Subject: RE: BR/145/19/PL : 9-11 Abbeyfield

PROPOSED GROUND FLOOR

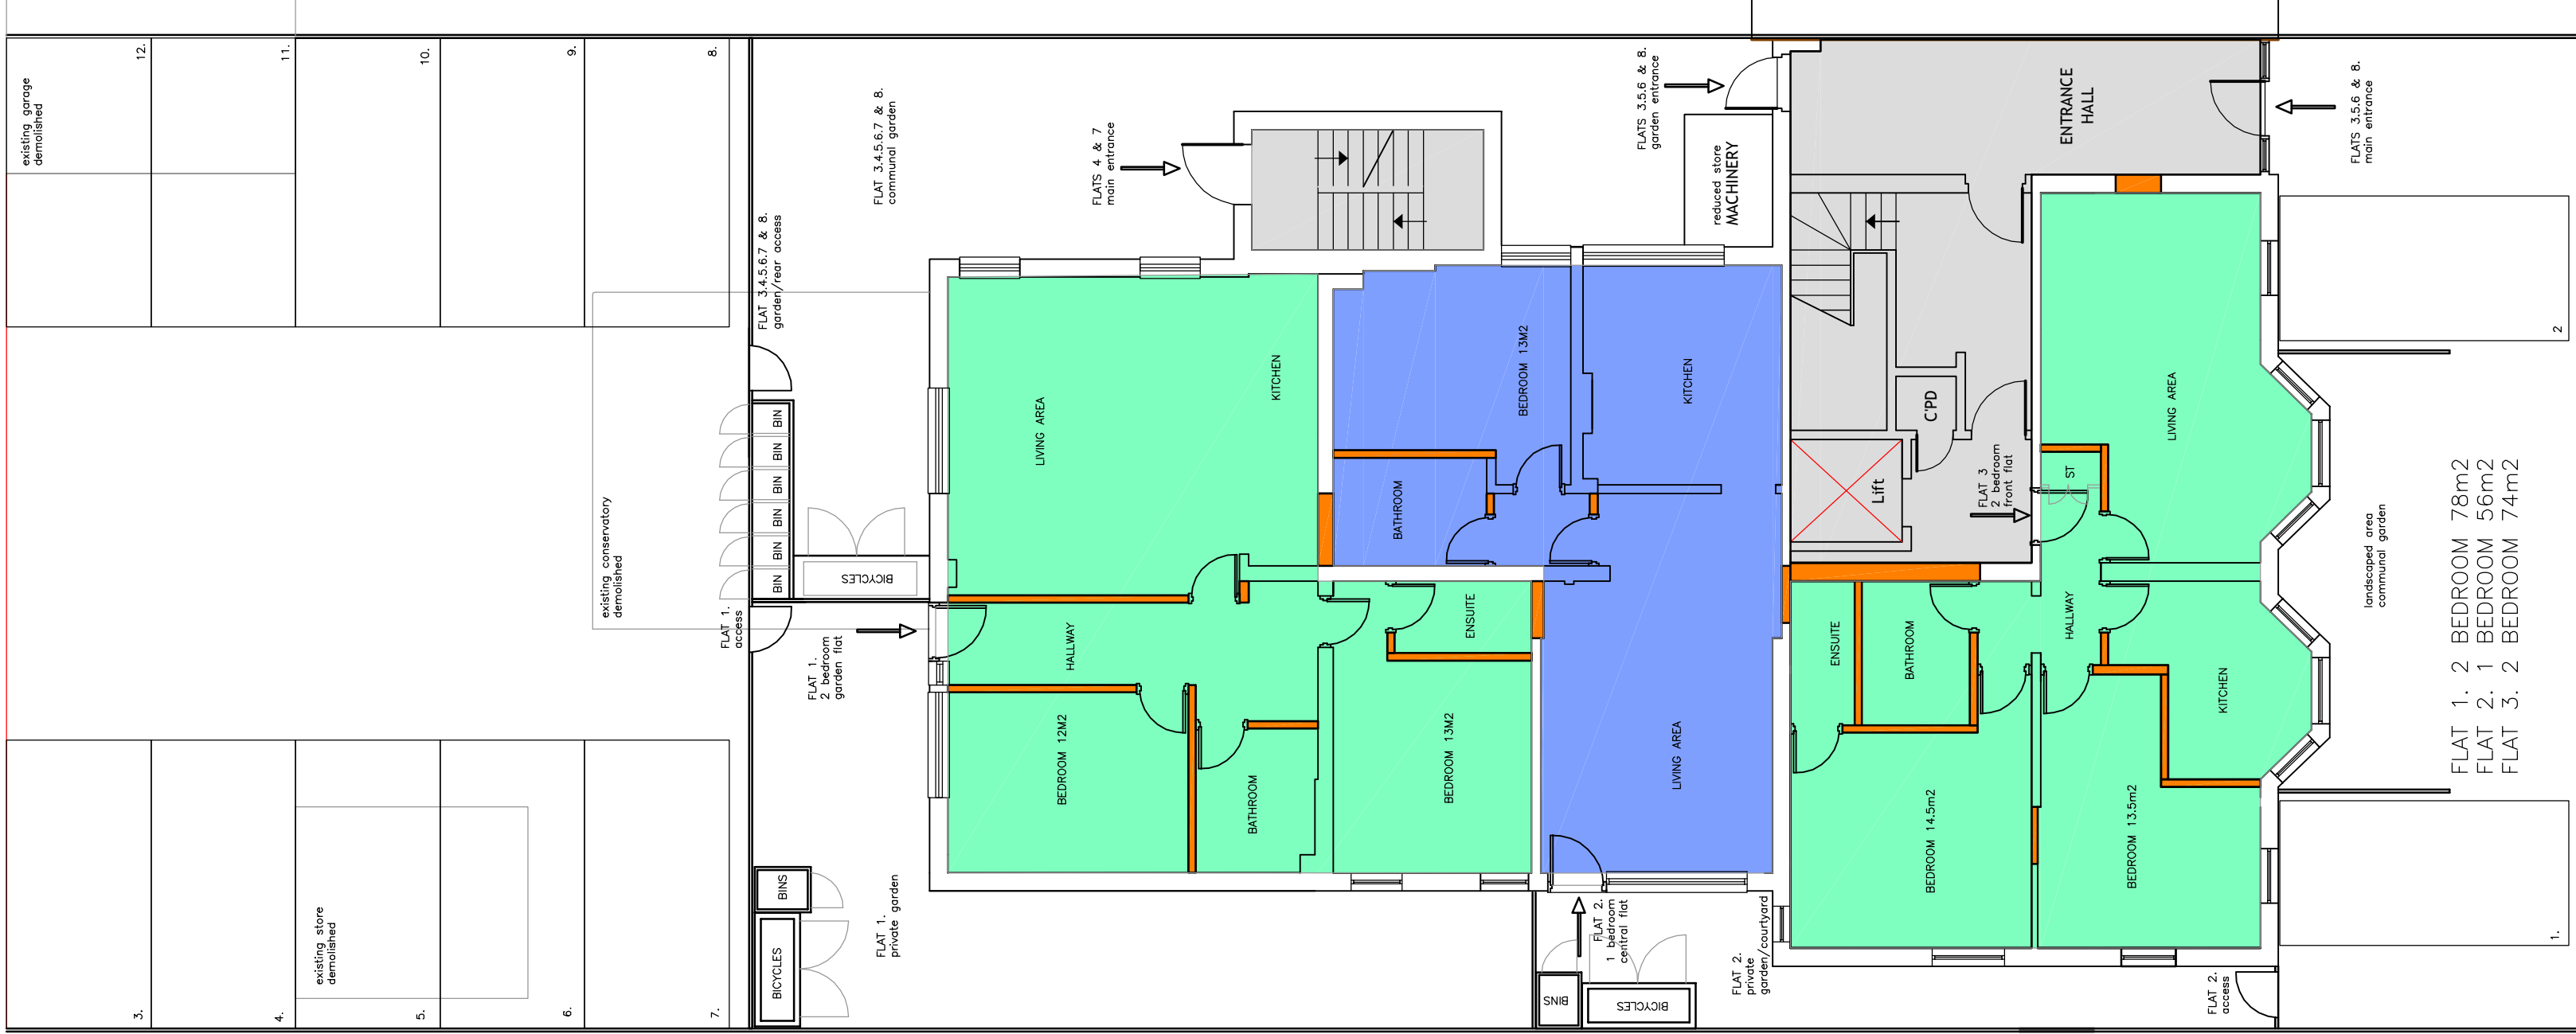
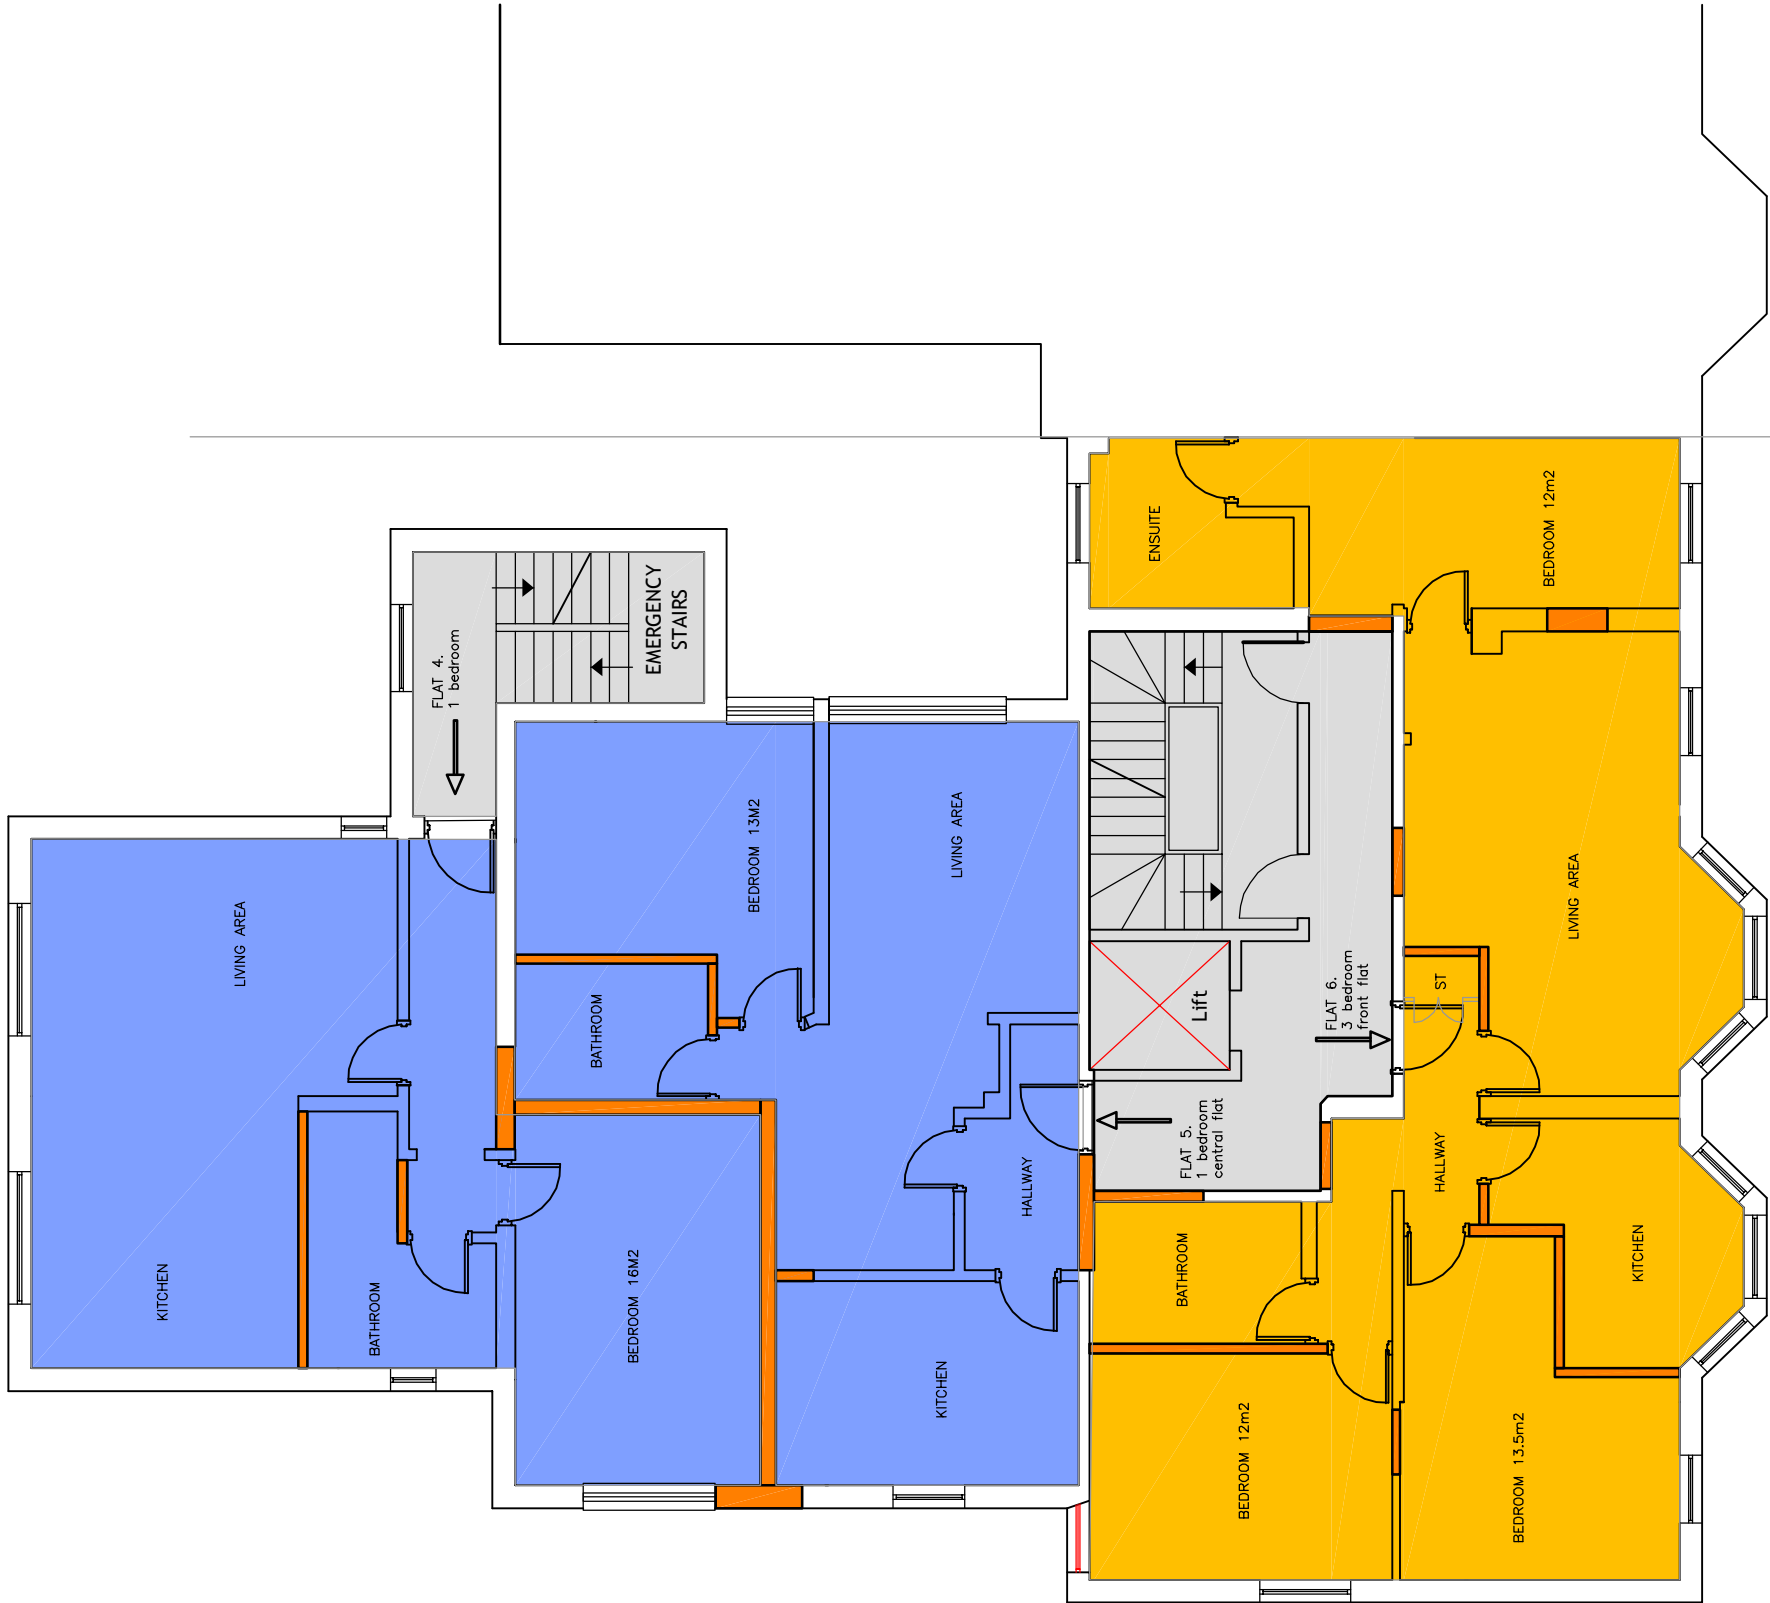
Please see WSCC Highways comments which are also available to view on our website. Can you respond to the points raised. Aside from this, I have no major planning concerns with the scheme. However, I would like to know what the proposed bin/cycle stores will look like and if one or both will be a wooden structure then I would not consider it appropriate to sit within the front garden area of the site. There do not seem to be any other similar structures in the street scene.

1. The rear parking layout has been rearranged to remove the narrow arrangement.
2. The grey box will be relocated to allow sufficient parking in bay 1.
3. Bins are all to be located to the rear of the property. Bin lorries currently reverse down this rear driveway to the rear of the site.
4. I attach a generic bin and cycle store arrangement, having removed the structure from the front garden.
